Design and Access Statement Plot B - Addendum

01997-WEA-OXFORD NORTH PLOT B-DAS-ADDENDUM-P02

This document is an addendum to the Plot B Design and Access Statement, 01997-WEA-OXFORD NORTH PLOT B-DAS-P01 submitted to Oxford City Council in March 2023 and Addendum P02 submitted in June 2023.

Following the initial Oxford North Plot B Reserved Matters Application submission further amendments have been reviewed following ongoing engagement with the specialist contractors. Issues were raised regarding buildability and embodied carbon which have led to a number of small amendments to the initial scheme.

Project
 Oxford North Plot B
 Drawing Title
 Wing Long Sections
 Scale at A1
 As indicated
 Drawing and CAD File Number
 01997 - WEA - XX - XX - DR - A - P3001
 Rev
P02
 © Wilkinson Eyre Architects Ltd

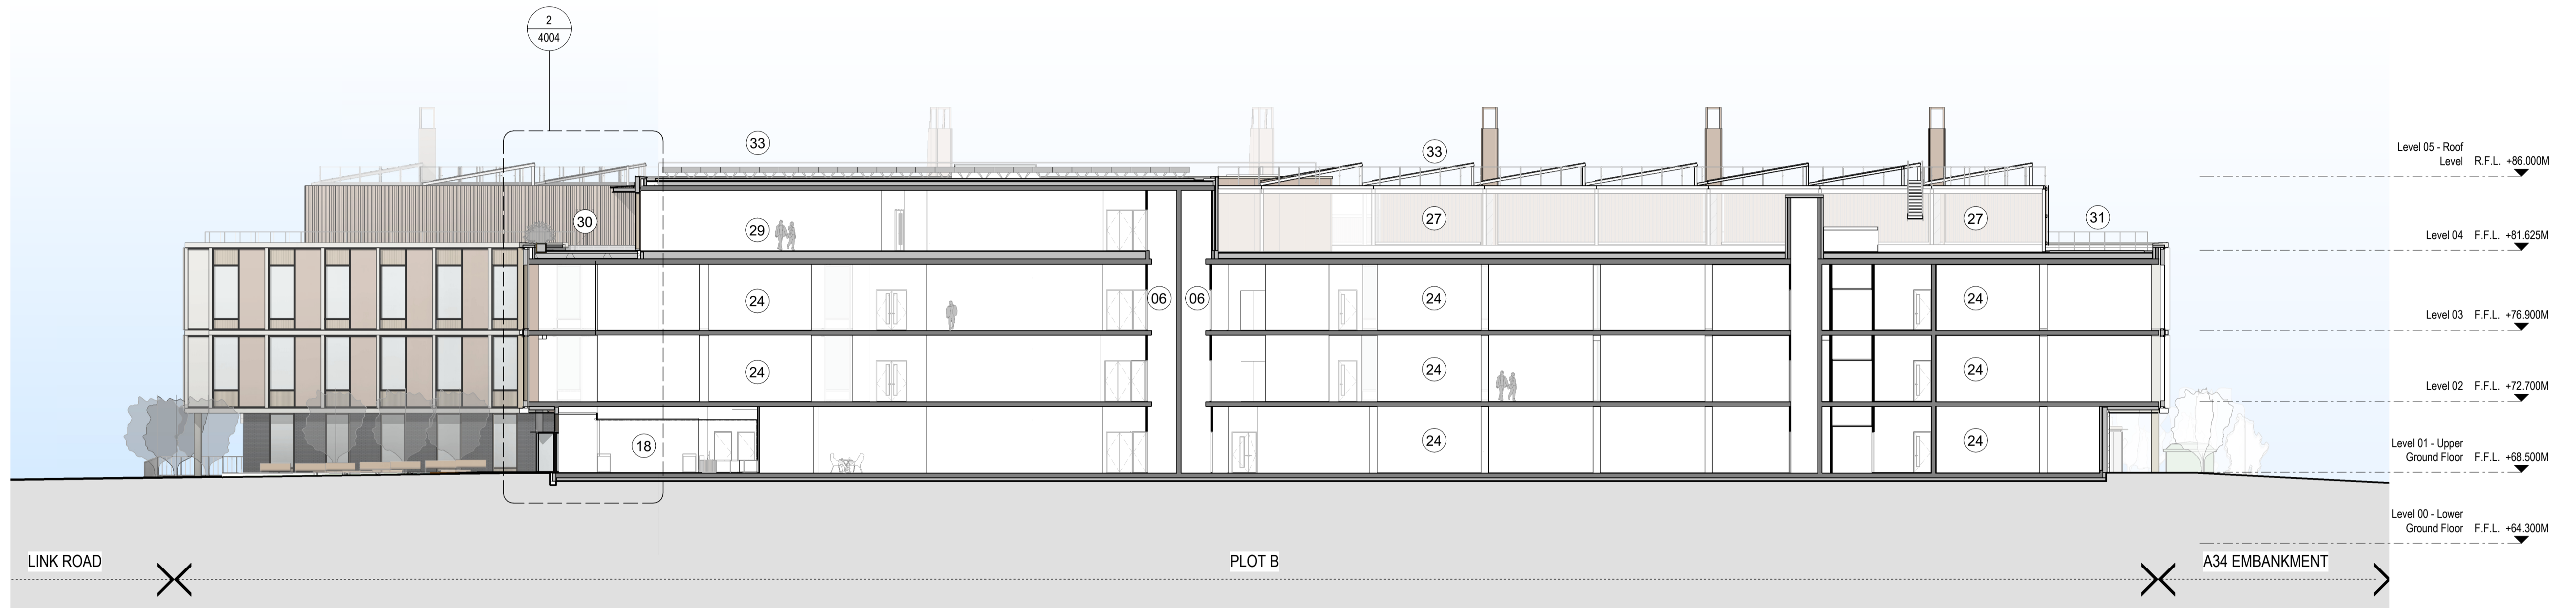
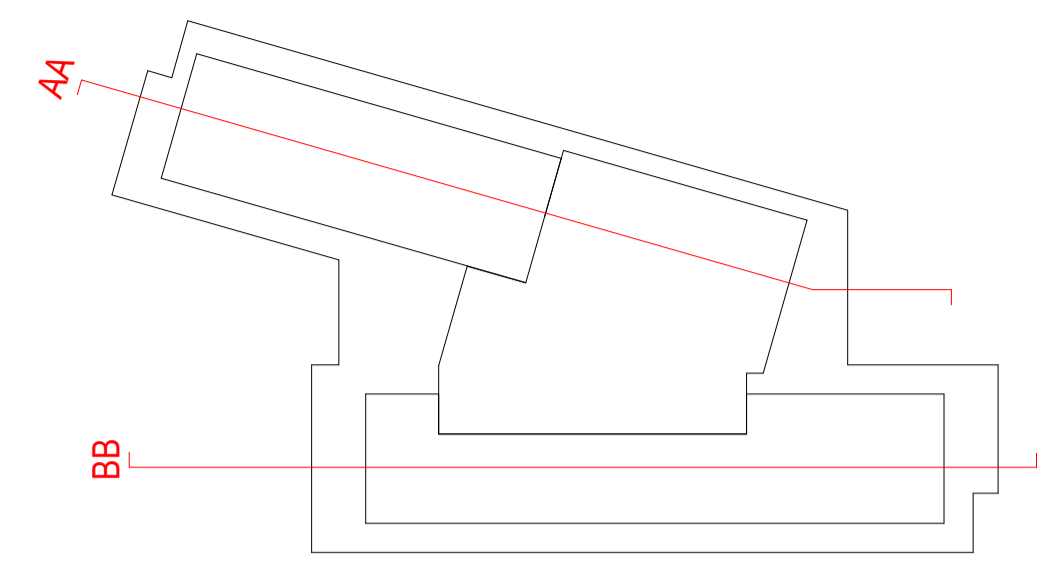
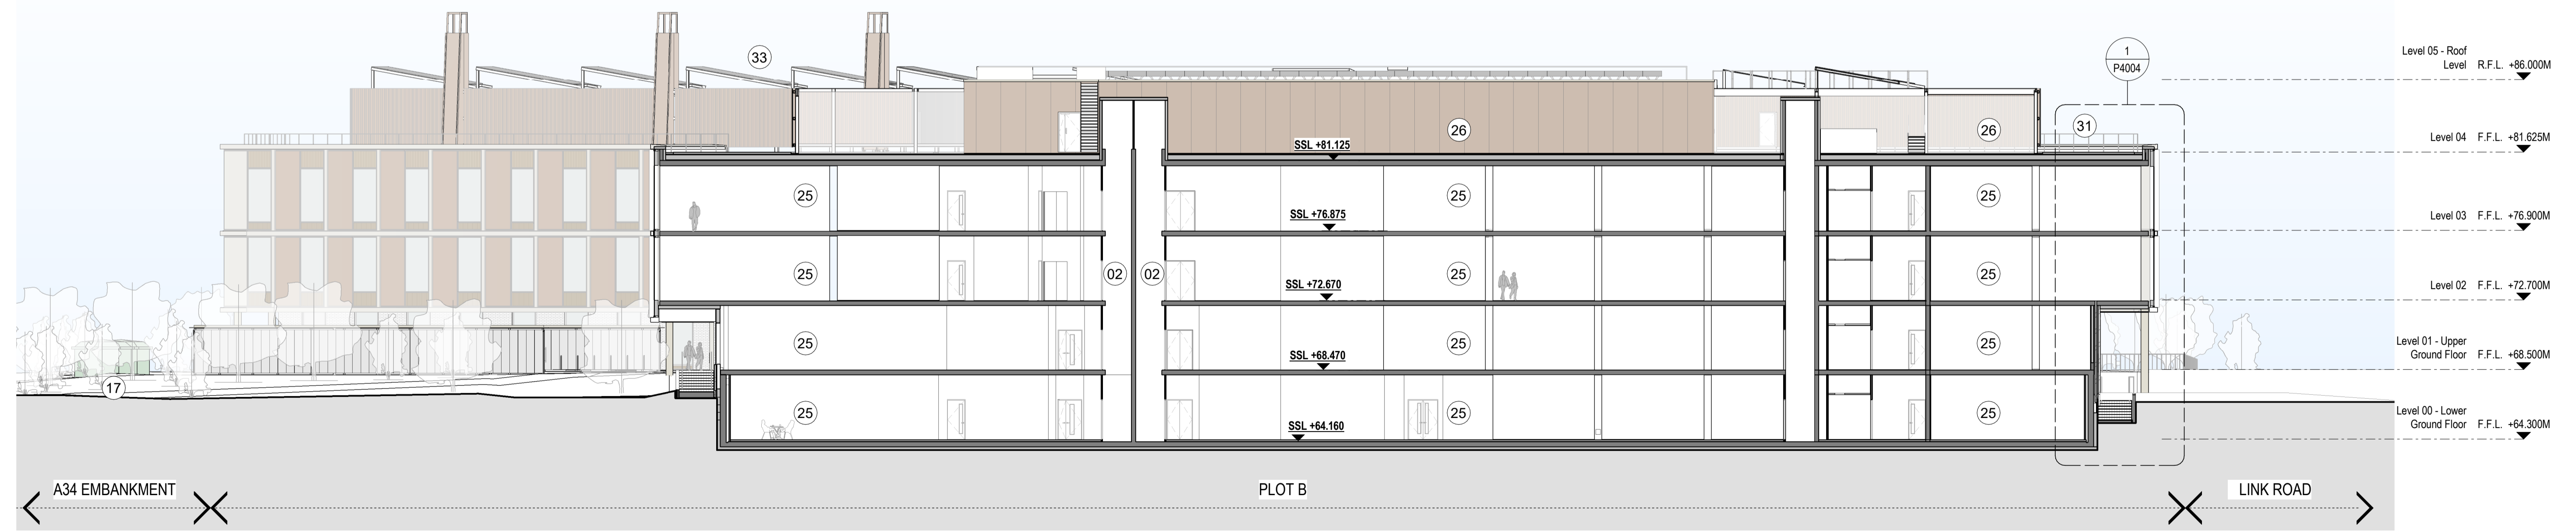
The views for this end of the building also illustrate the proposed update to the fume extract chimneys. One flue has been removed to the north wing where there was previously an over provision. The three remaining flues have been set out to remain clearly visible and suit the locations of the duct work service risers.

The plant screen height has also been reduced which is consistent across the scheme and allows more emphasis on the profile and rhythm of the solar voltaic panels behind.

- 01- Flue removed with others redistributed
- 02- Service pavilion cladding amended to perforated aluminium sheets with adjacent GRP Substations
- 03- Facade articulation depth reduced
- 04- Flat cladding to gable end amended to vertical fins and setting out consistent along elevation
- 05- Reduce plant screen height

Project
Oxford North Plot B
Drawing Title
Northern Wing Entrance Facade Study

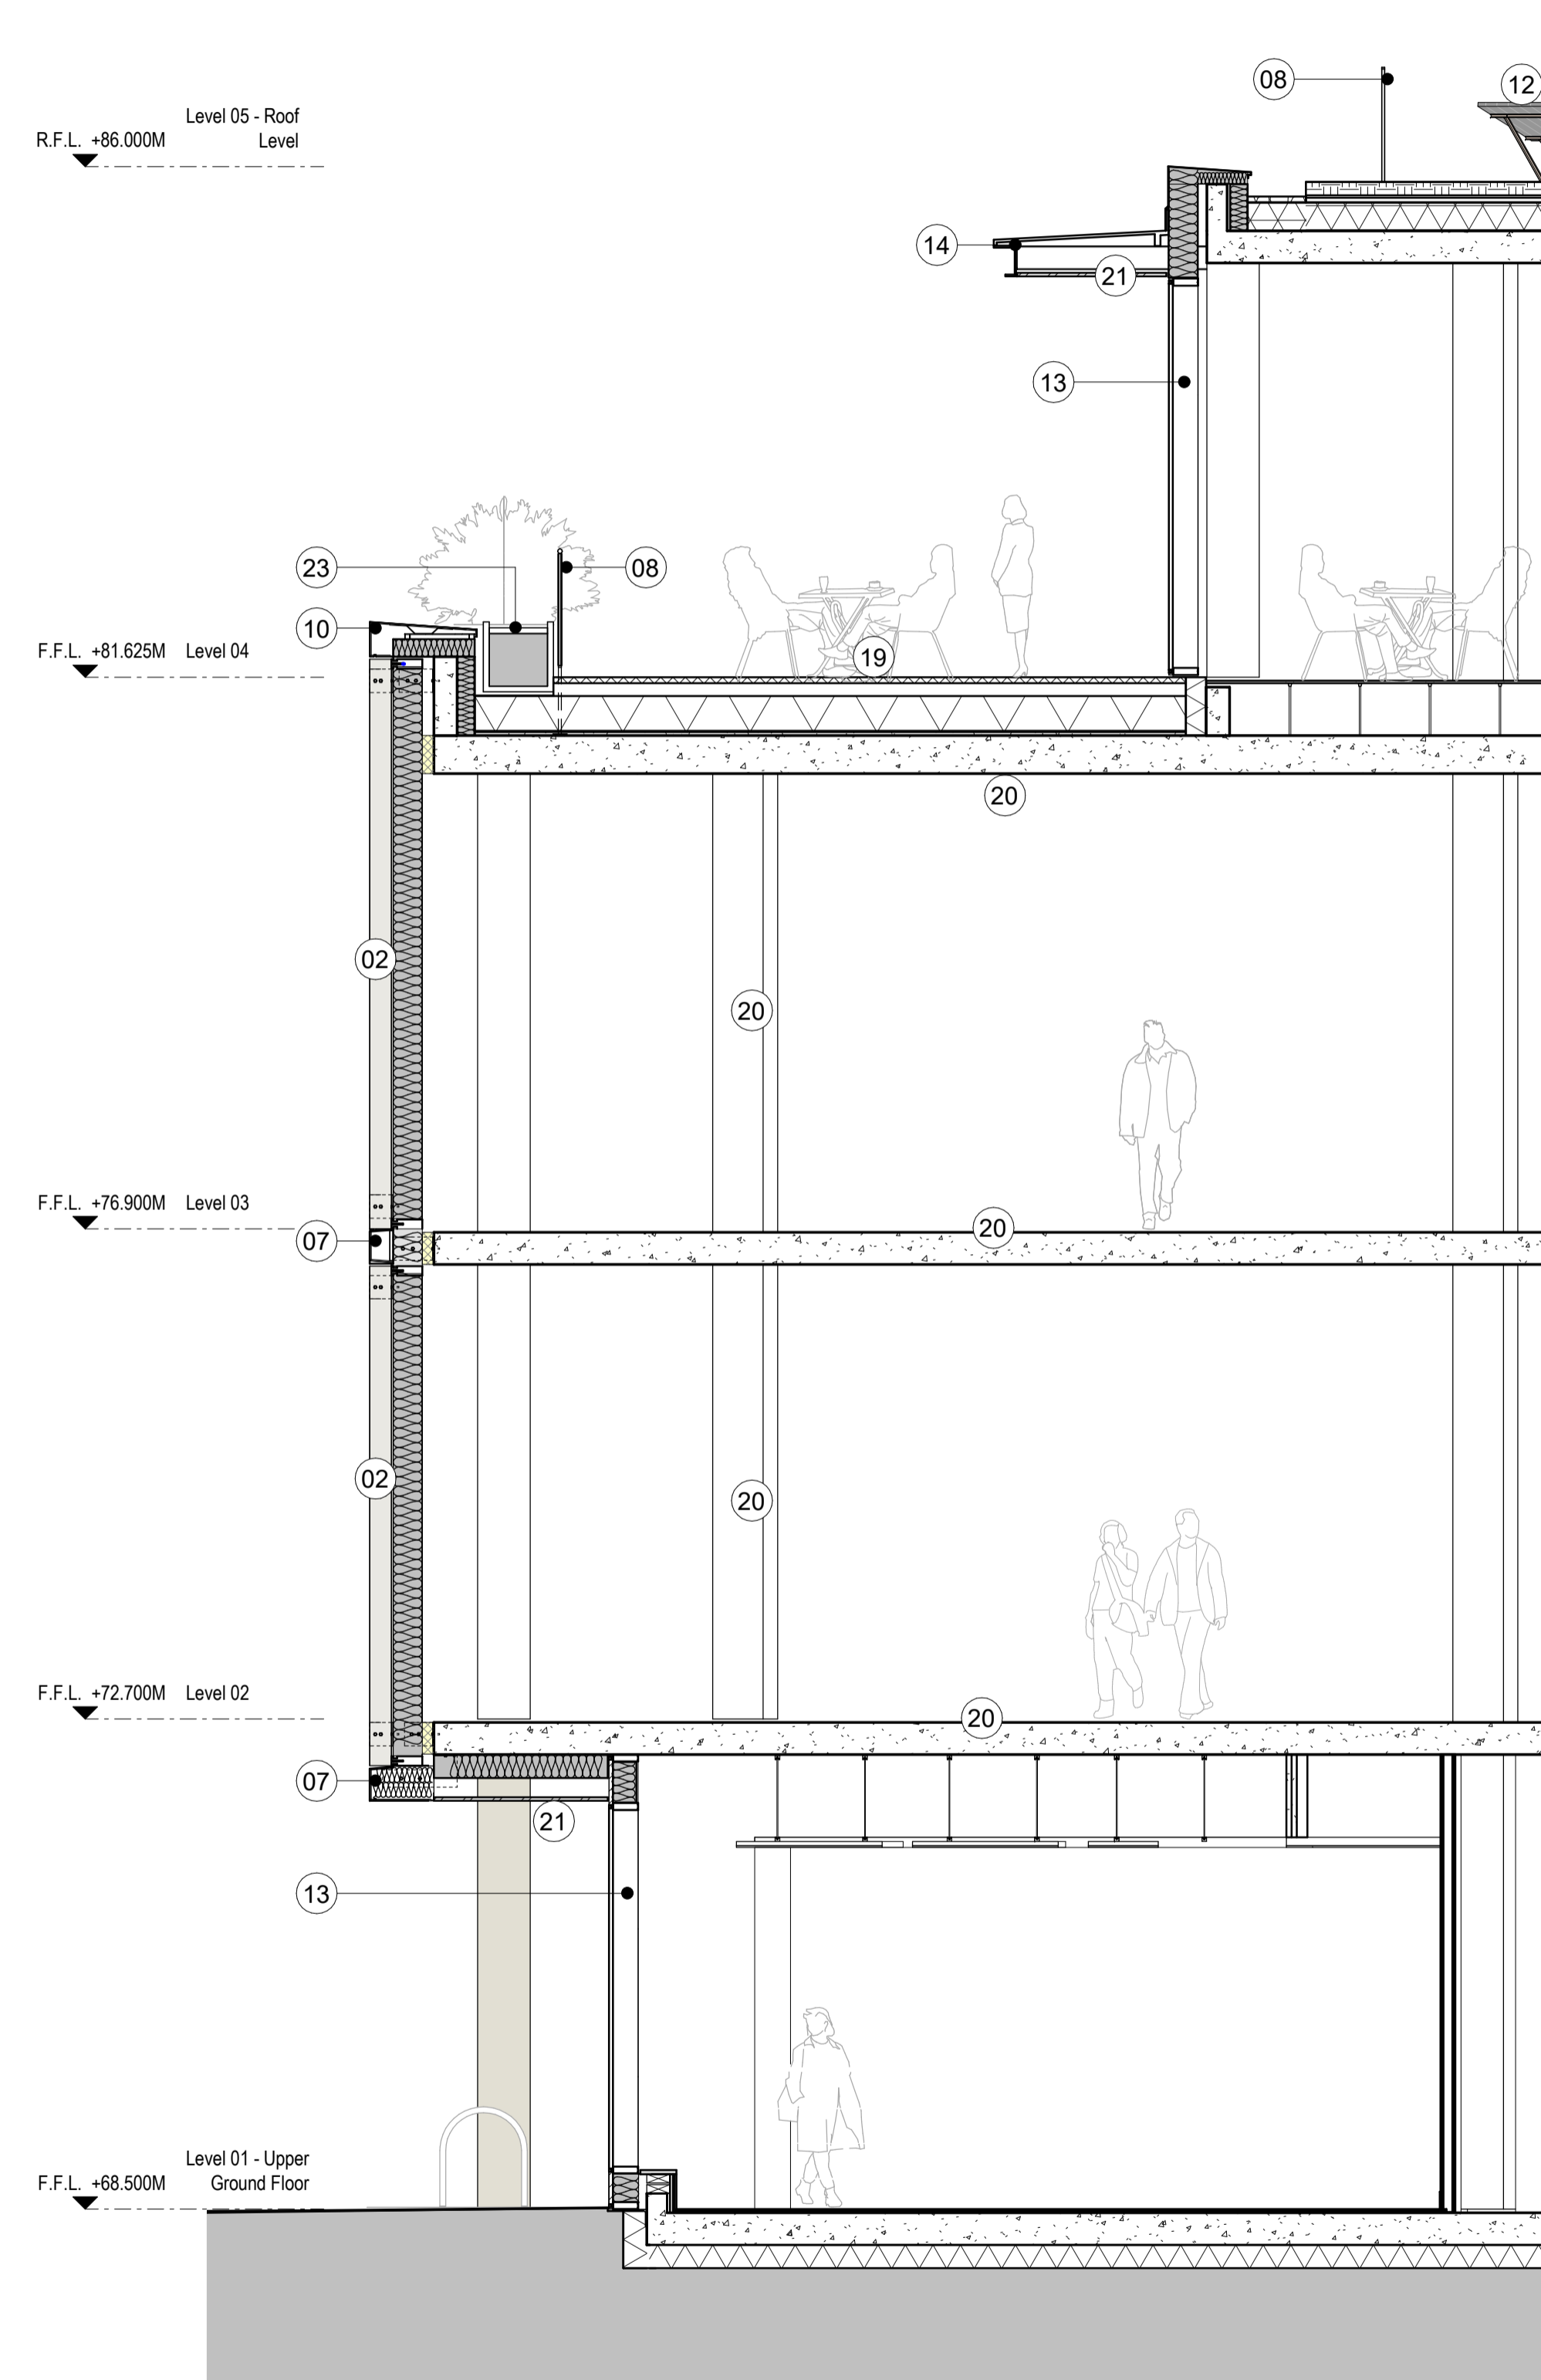
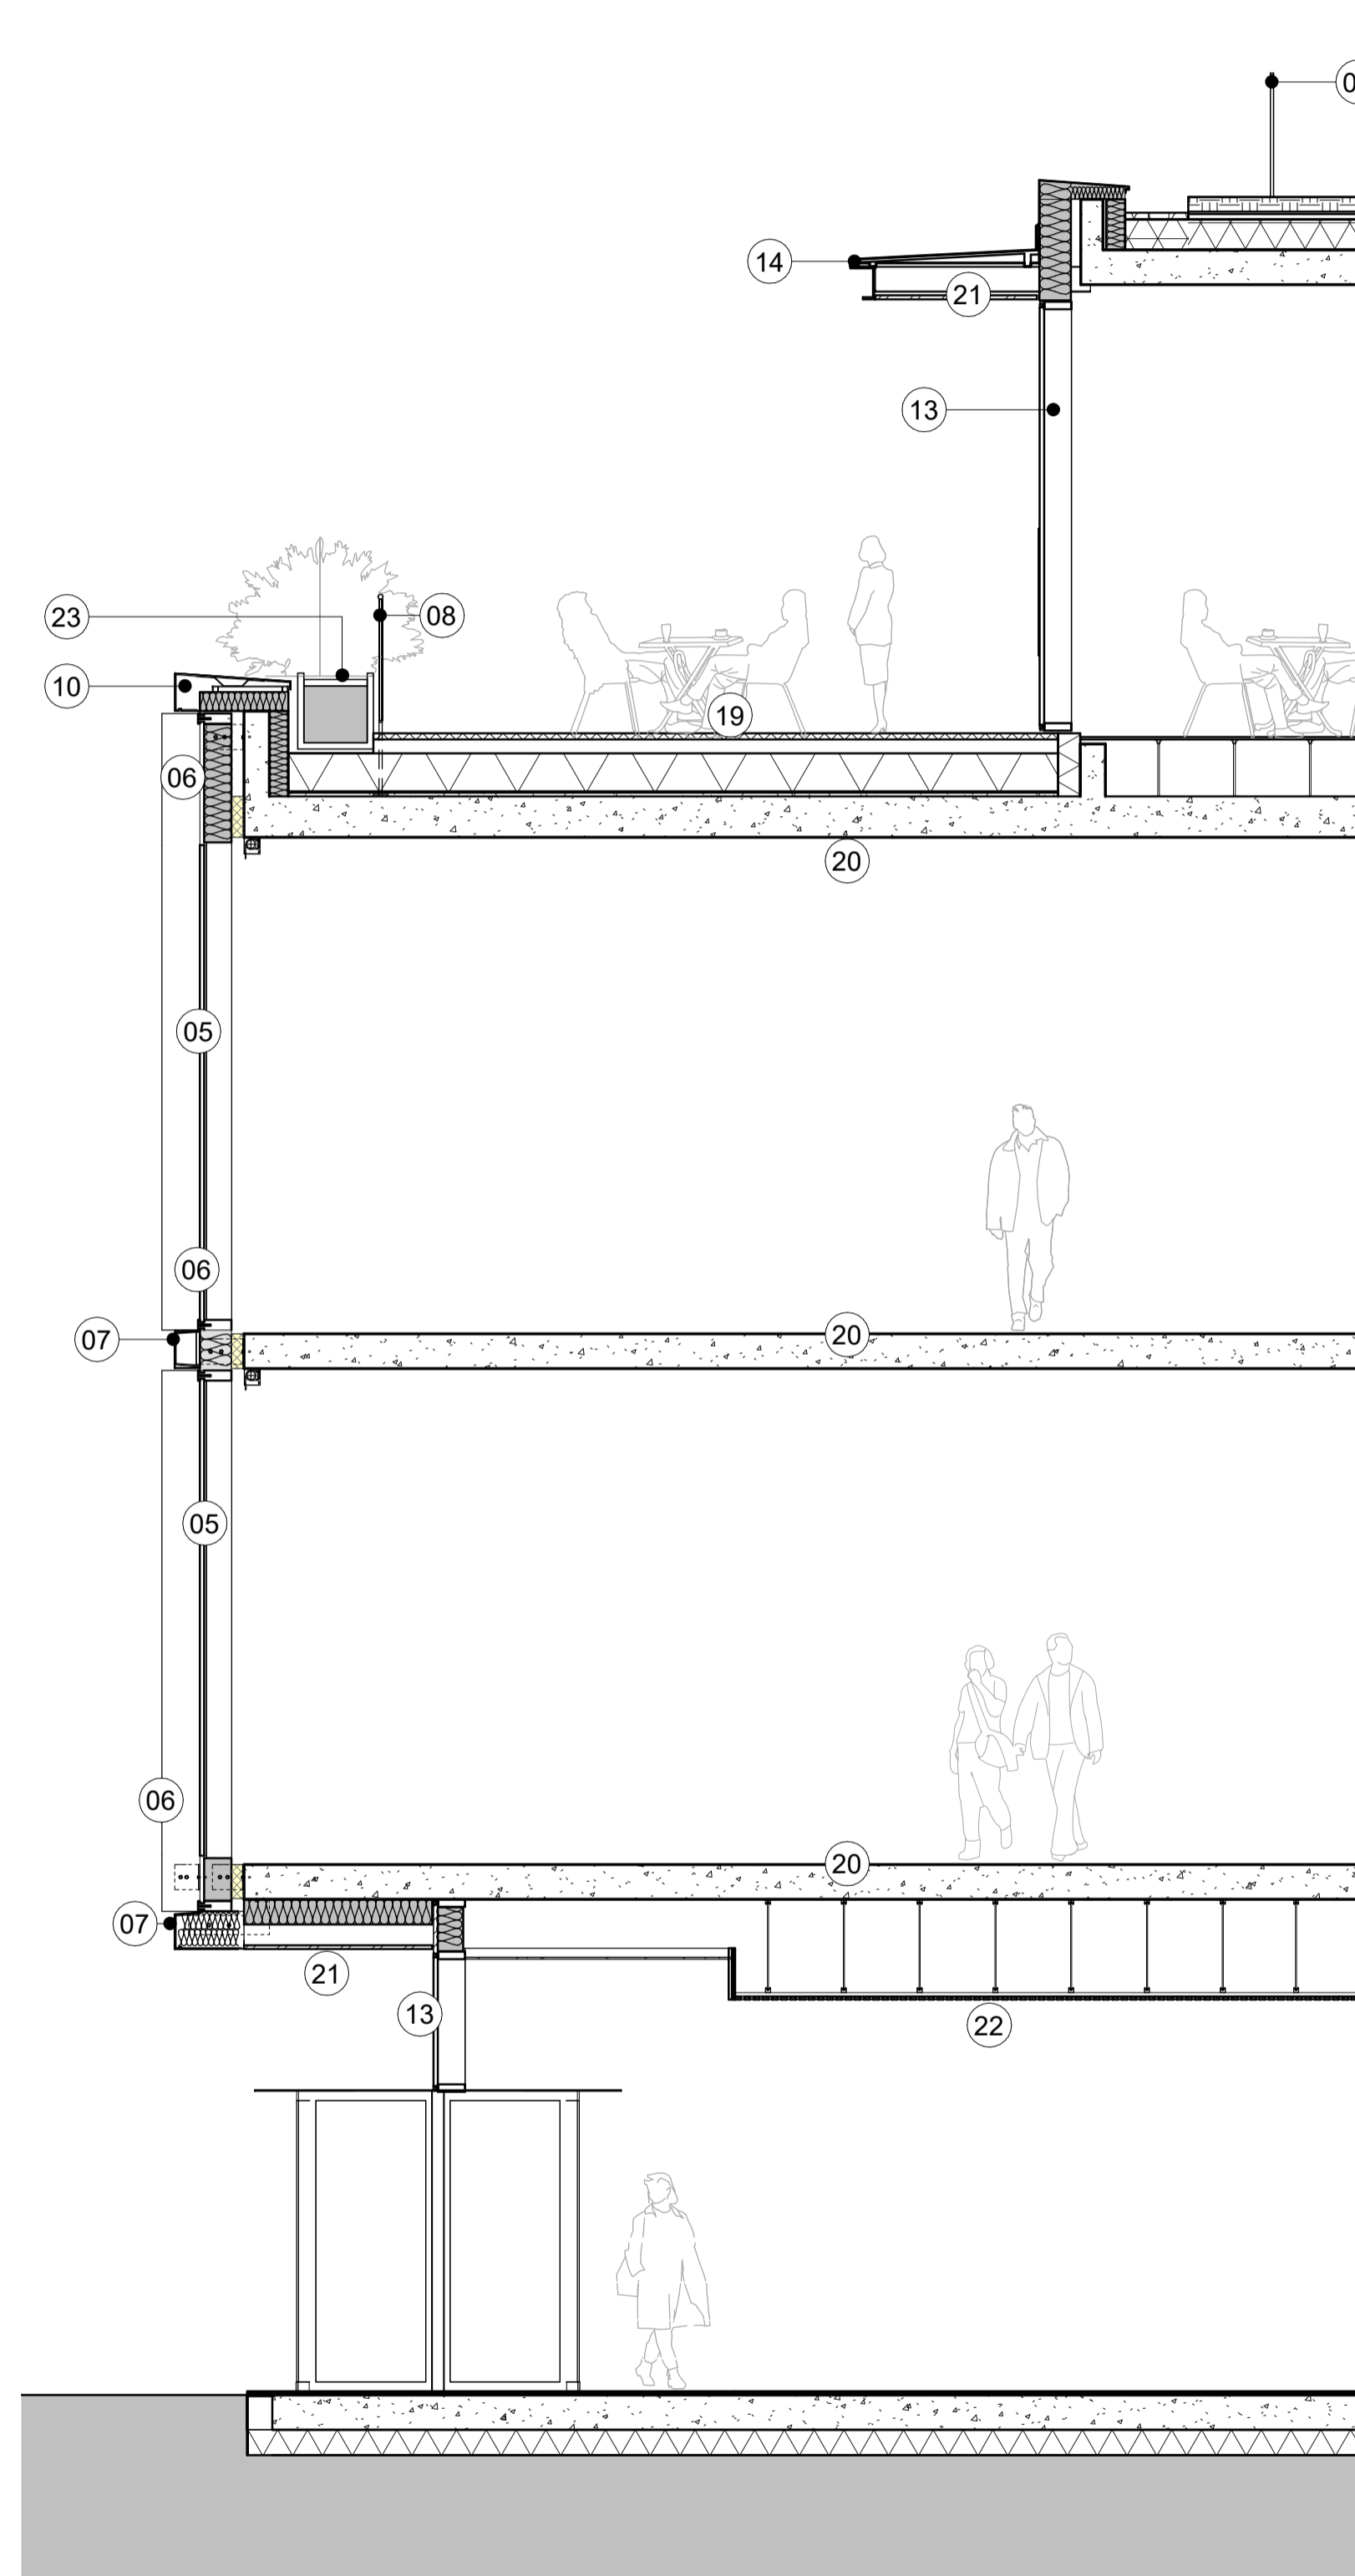
The key change to the scheme has been the reworking to the eastern end of the north wing to the building. Following buildability reviews with the preferred main contractor, the acute junction of the entrance elevation was identified as an area of significant complexity and difficult construction detailing. Therefore the design team reviewed an alternative orientation of this facade that was also considered could improve the composition of the forecourt space.

By amending the angle of the return elevation it was felt this entrance facade better framed the external forecourt space. As well as removing the awkward angle, it was felt the visibility of the entrance screen was improved. The width of the glazing screen was increased to provide a more open and transparent frontage. It was considered that this would enhance the relationship between the internal and external spaces.

The re-working of the entrance facade also involved amending the flat areas of cladding and provide more articulation through the use of vertical fins. This was intended to enhance the elegance of the facade and was adopted as common approach to each of the wing gable end elevations.

01- Square up building to East of North wing (over the main entrance)

02- Amend entrance screen to be wider and not recessed with canopy removed below.

04- Flat cladding to gable end amended to vertical fins and setting out consistent along elevation
